Application No: K/17/22/PL
Site Address: Panorama Golden Acre Kingston BN16 1QP
Description of works: Conversion of existing 2 No flats into 1 No dwelling, single-storey extension with a sloping roof, new porch on ground floor, conservatory at first floor and roof extension, replacement of existing windows, doors and roof tiles. This site is in CIL Zone 4 and is CIL Liable as new dwelling.

Thank you for your internet representation made on 29th July 2022 which has been recorded as an objection with the comments as follows:

PROPOSED SECOND FLOOR PLAN 1:50

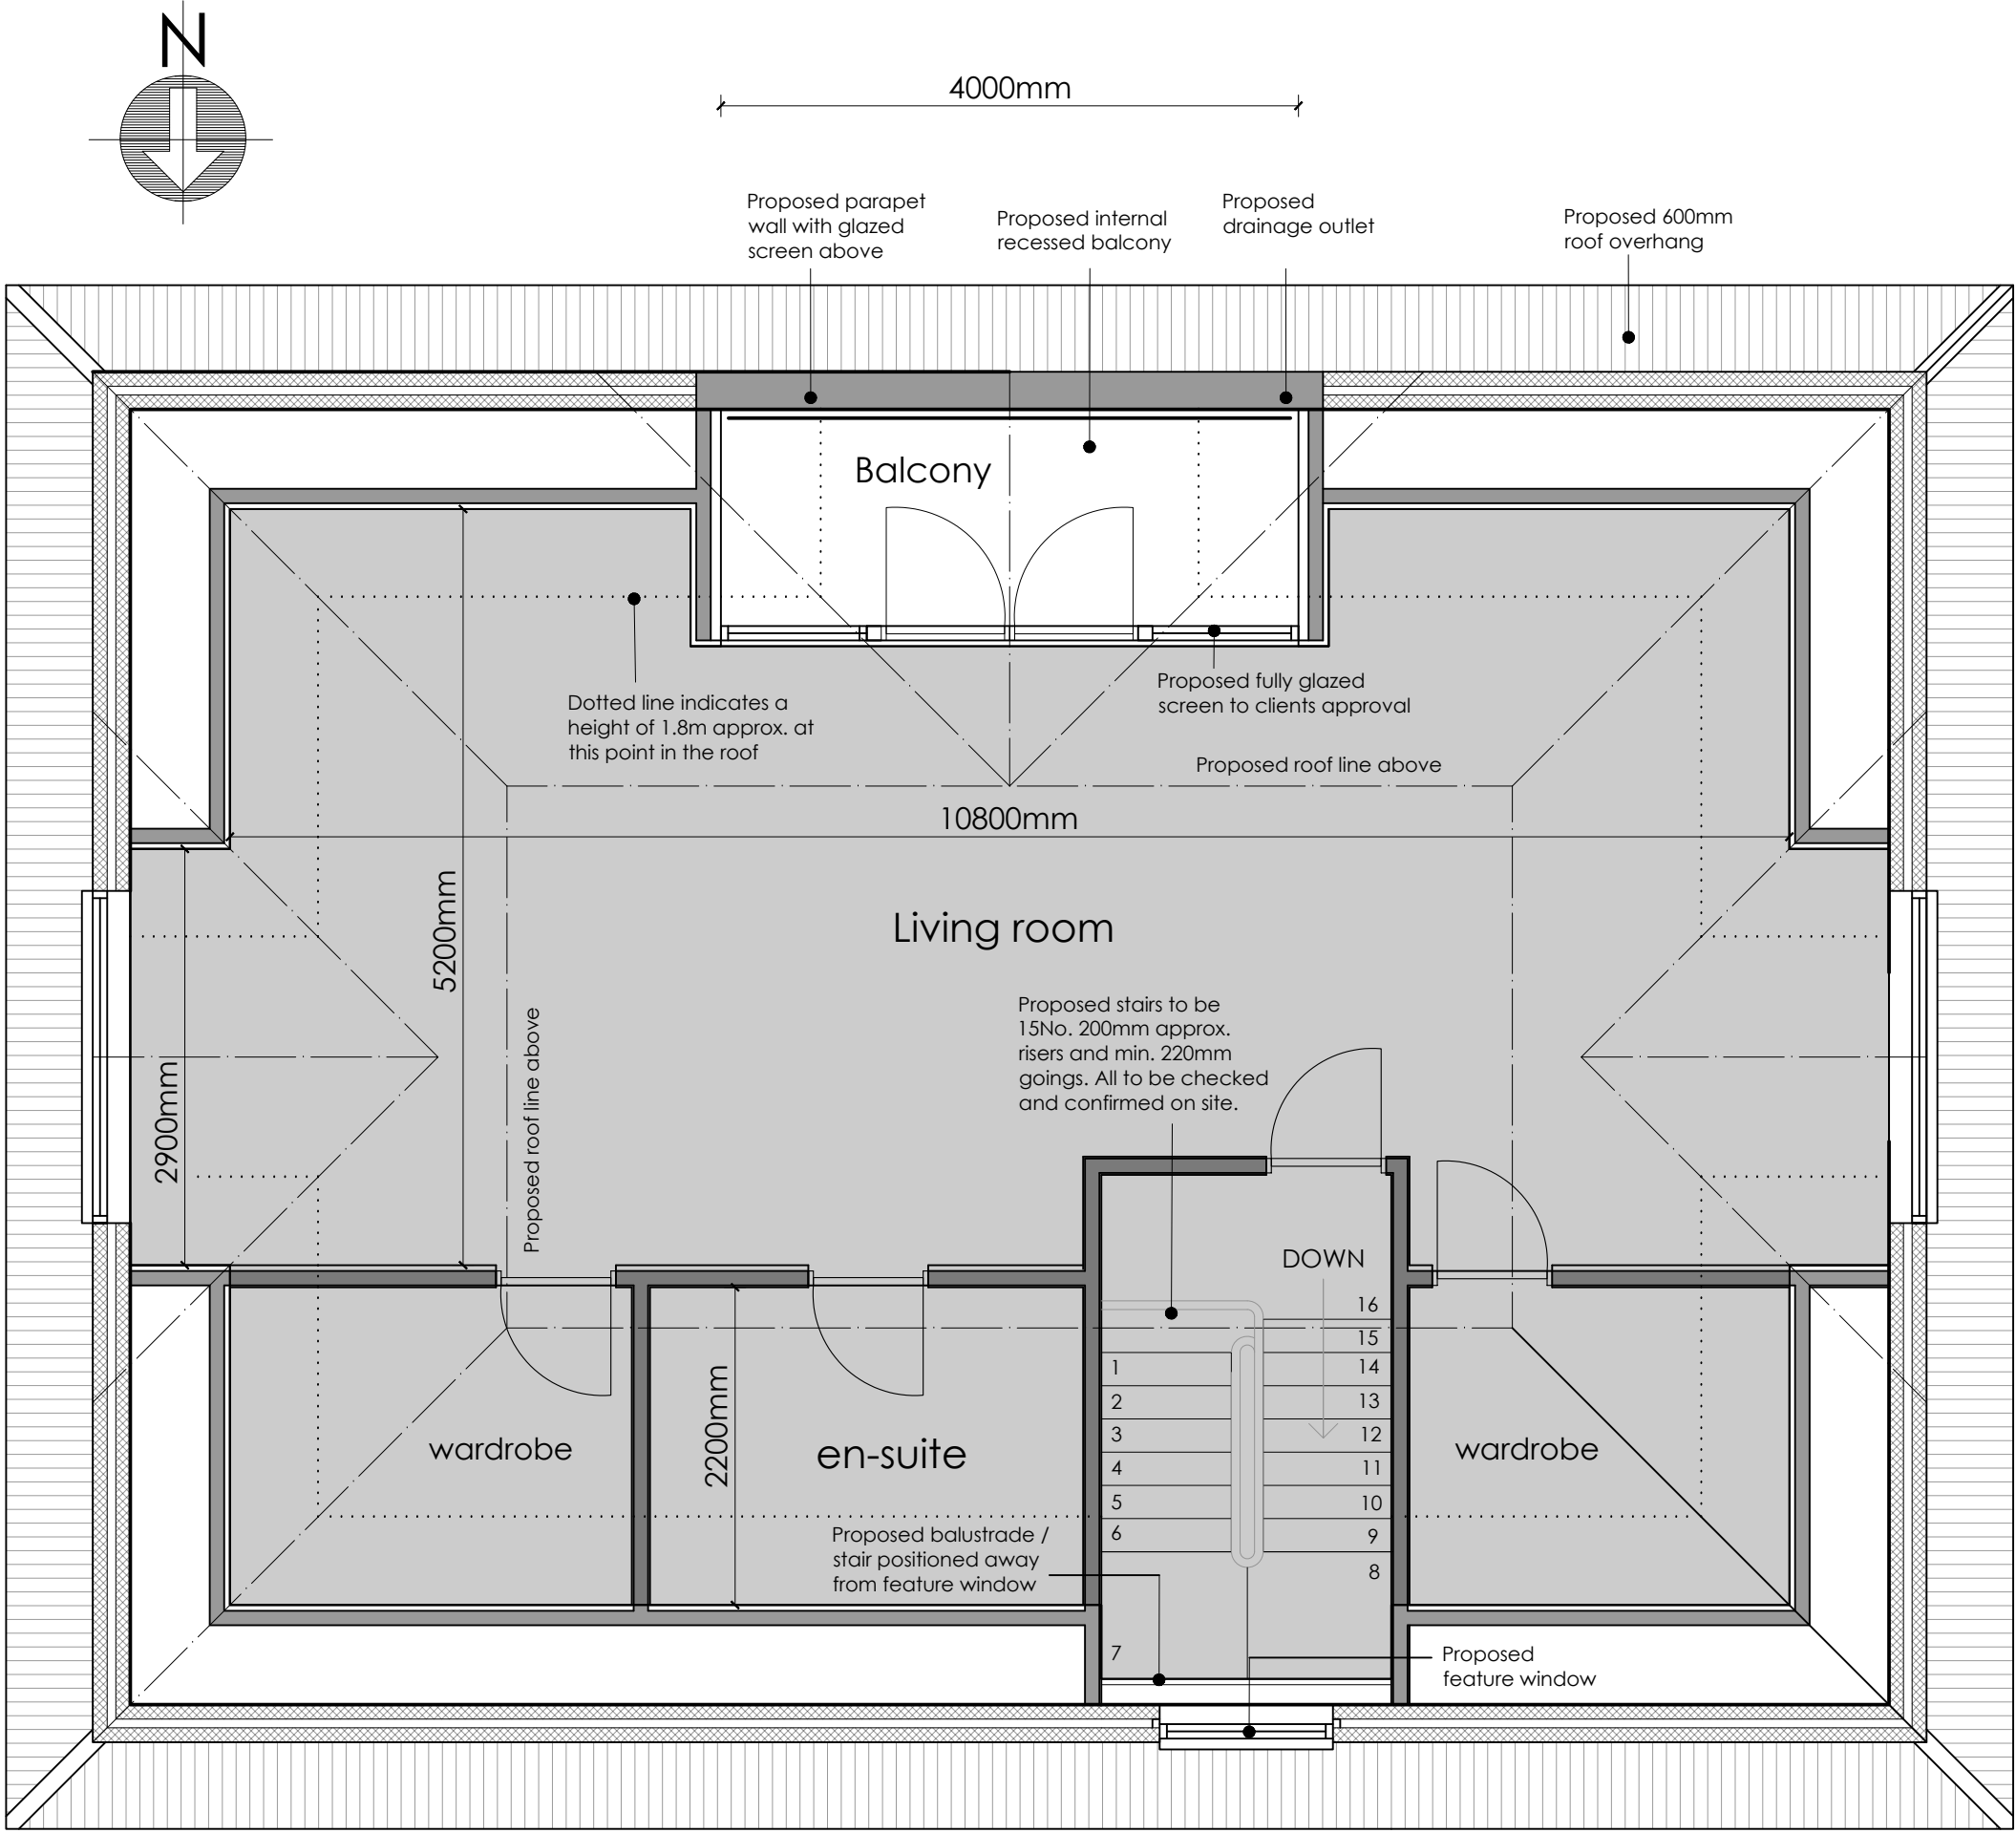
The proposed additional floor and windows (on the East and North Facing Elevations) would result in the occupants being able to see directly into our bedrooms, garden and living areas of our home. This would severely impact our privacy. My daughter's bedroom would be in direct site from the proposed 3rd floor windows - East and North facing. At the very least, the East and North Facing windows should be obscured with the use of privacy glass if these plans are approved.

The proposed plans, if approved, would result in a house that would not be in-keeping with the neighbouring houses and area - it would be far too large a property for its prominent position at the end of the Greensward.
